CITY OF ALBUQUERQUE

Re: Blue Grasshopper 3
1401 2nd St. NW
30-Day Temporary Certificate of Occupancy
Transportation Development Final Inspection
Engineer's/Architect's Stamp dated 11-16-17 (J14D189)
Certification dated 5-20-19

1 SITE LAYOUT PLAN

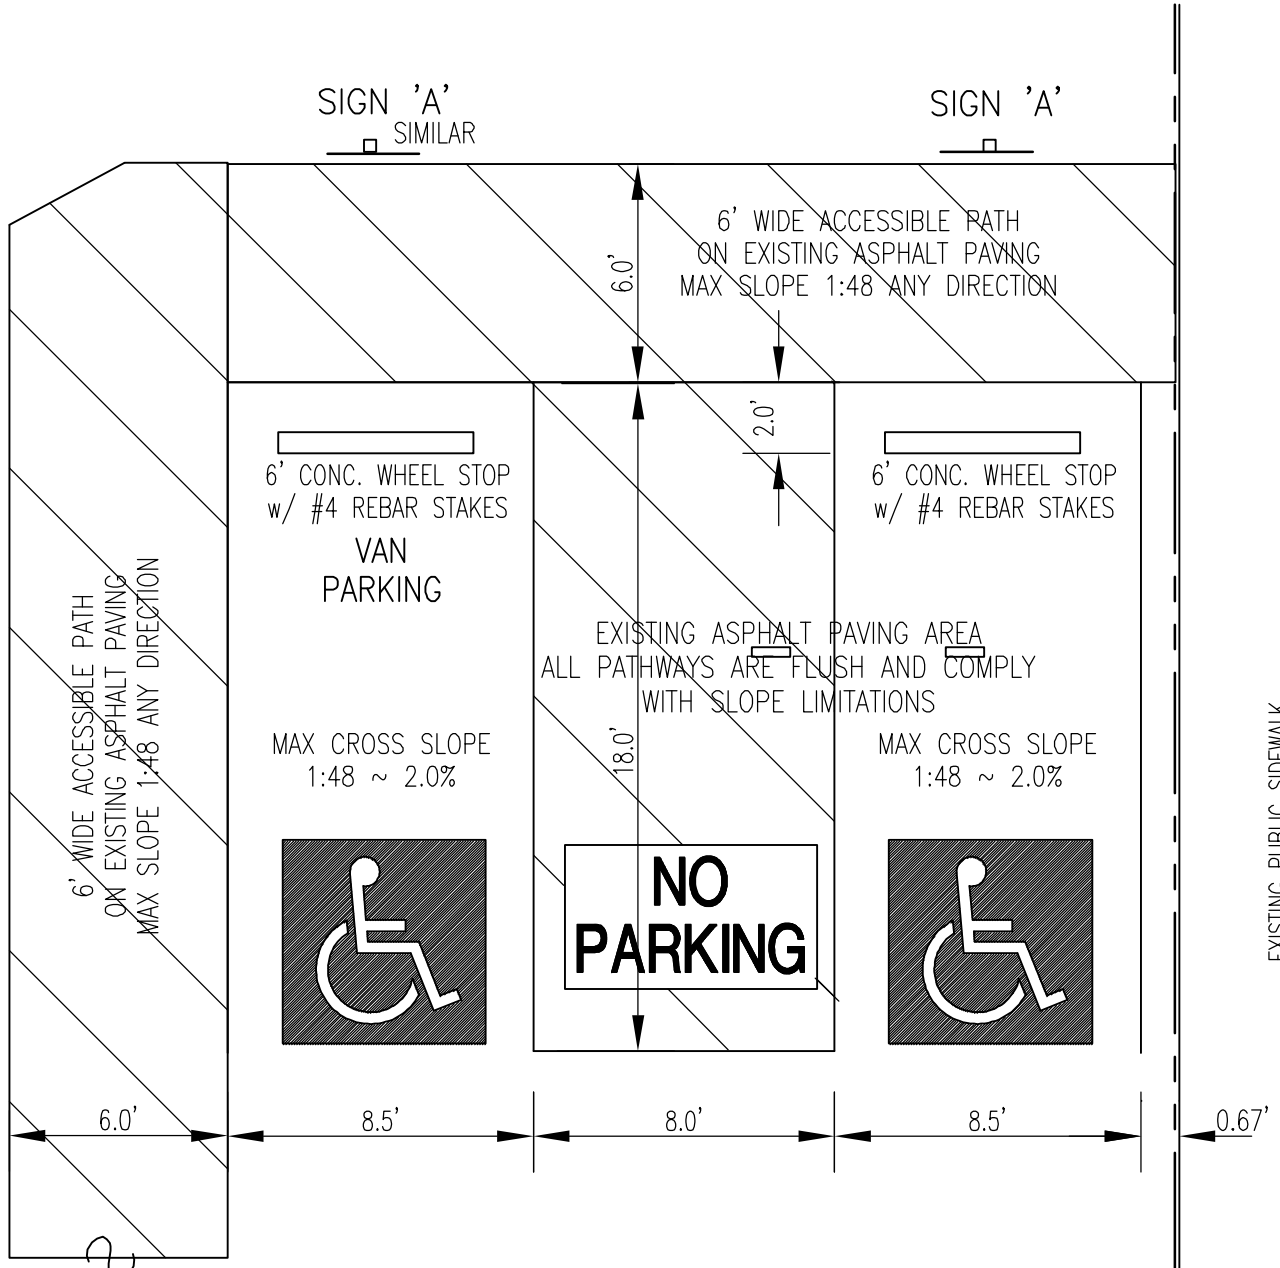
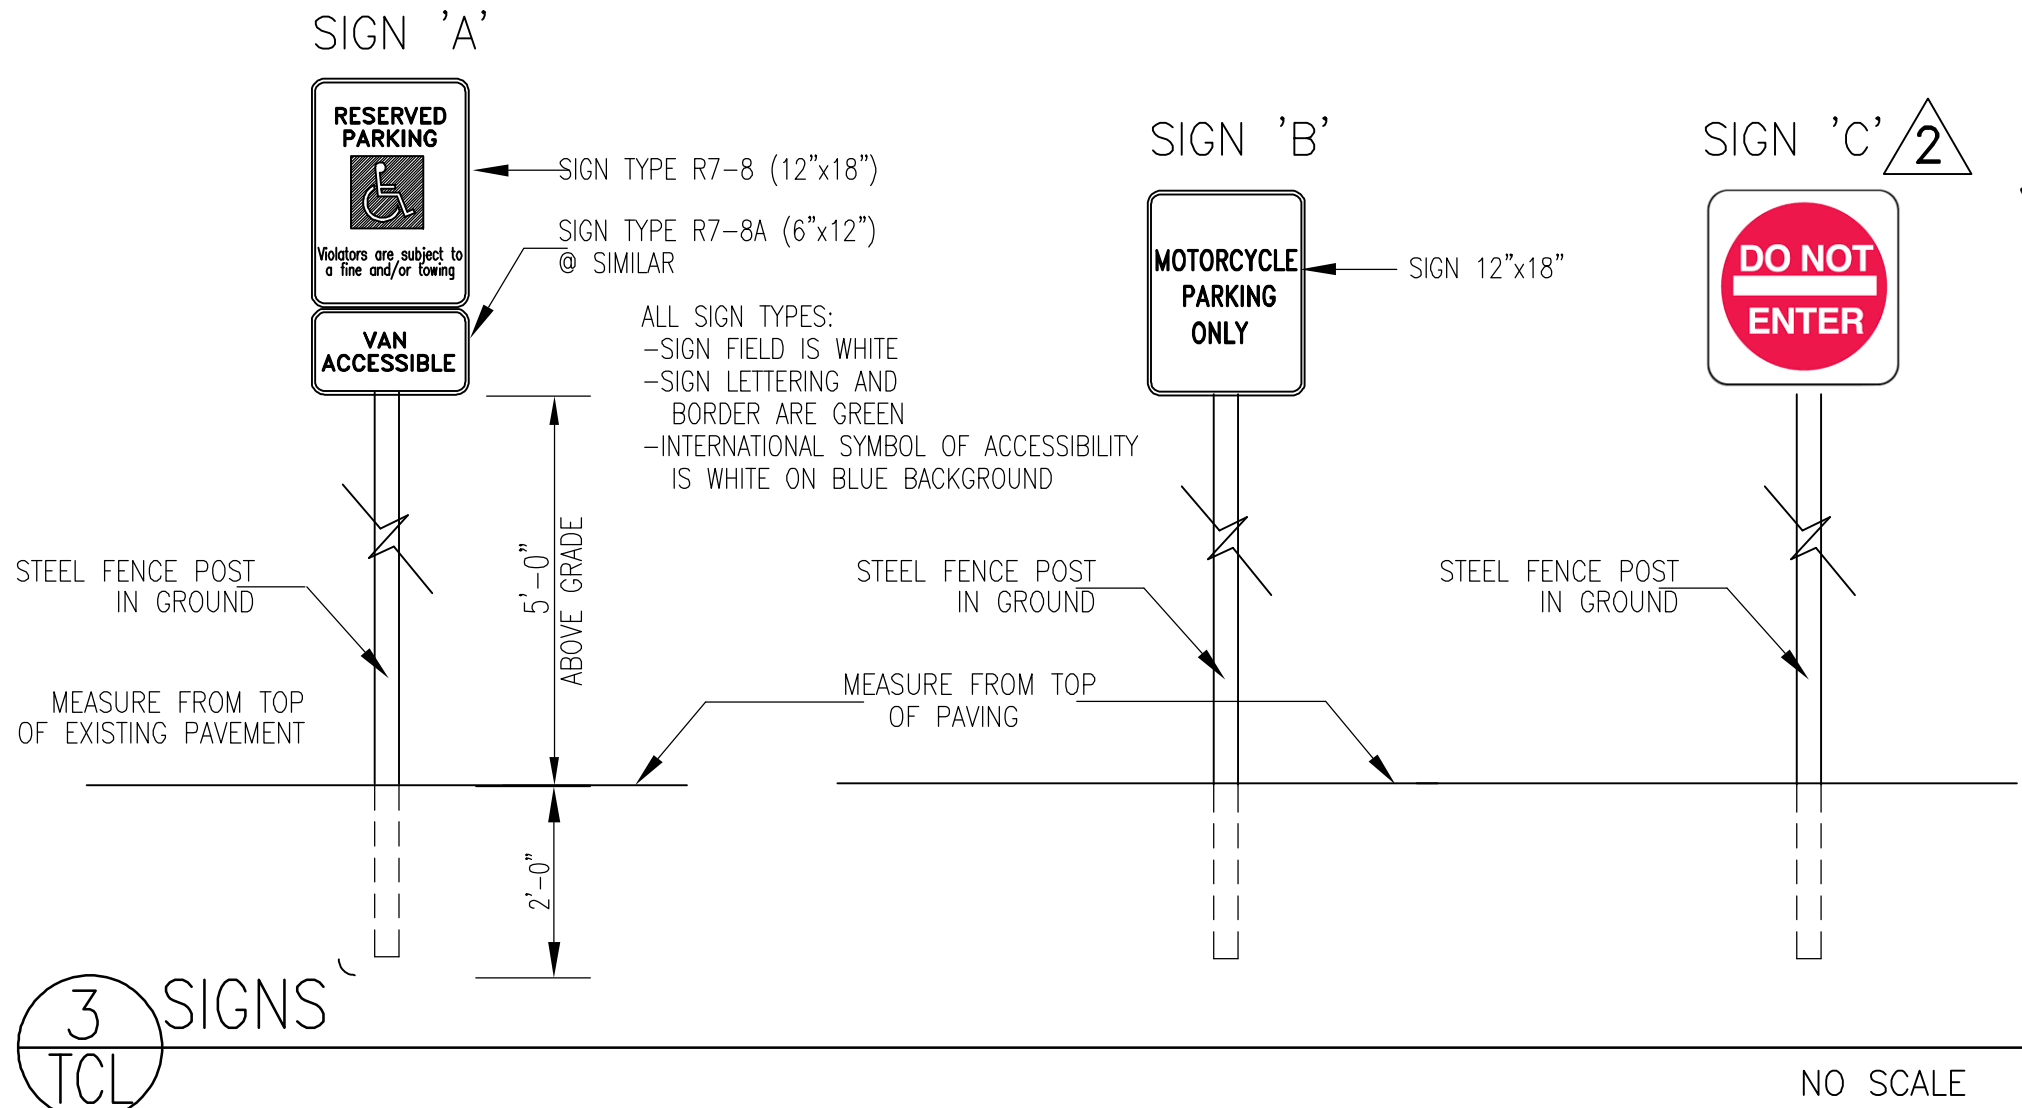
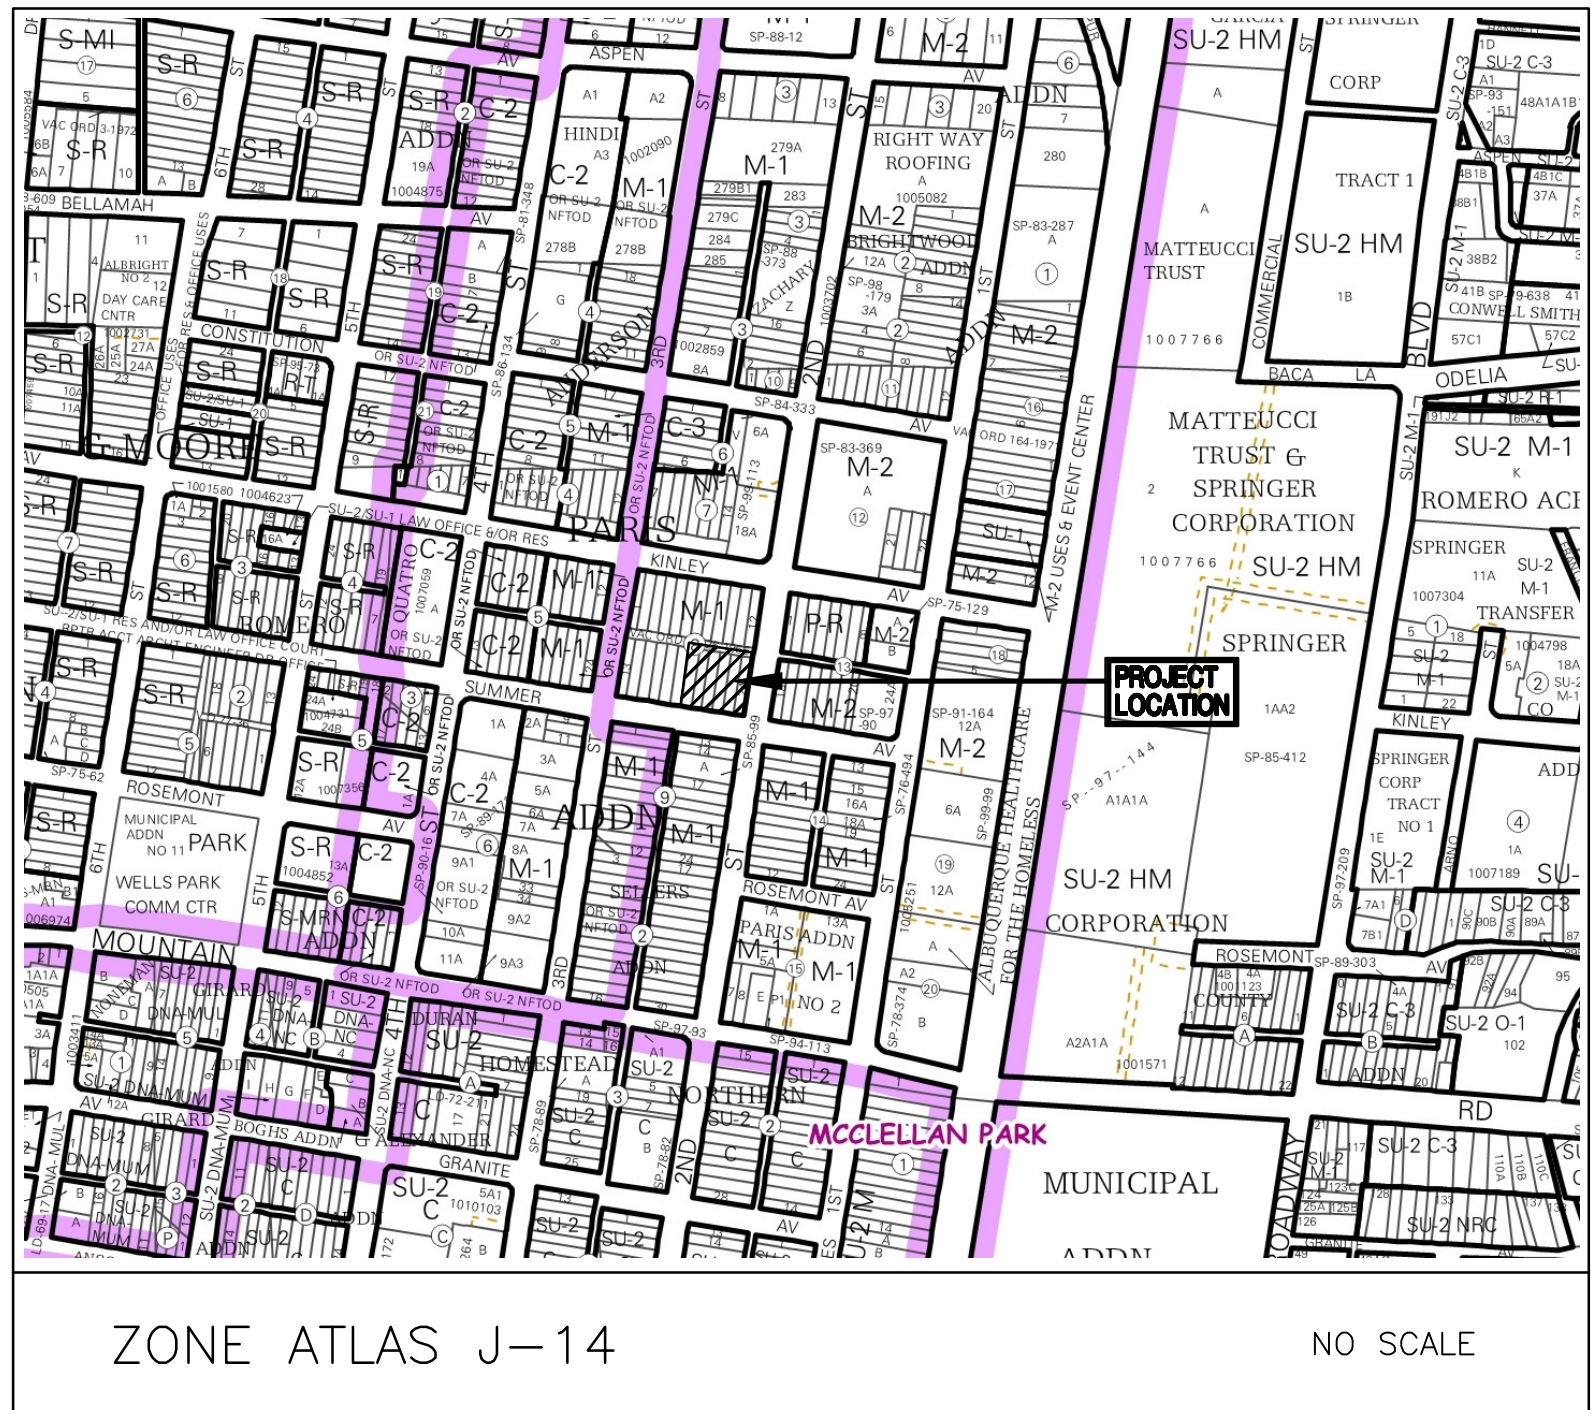
1. Please label single parking stall with utility pole as COMPACT.
2. Please send photo of correction to epgomez@cabq.gov for release of final CO.
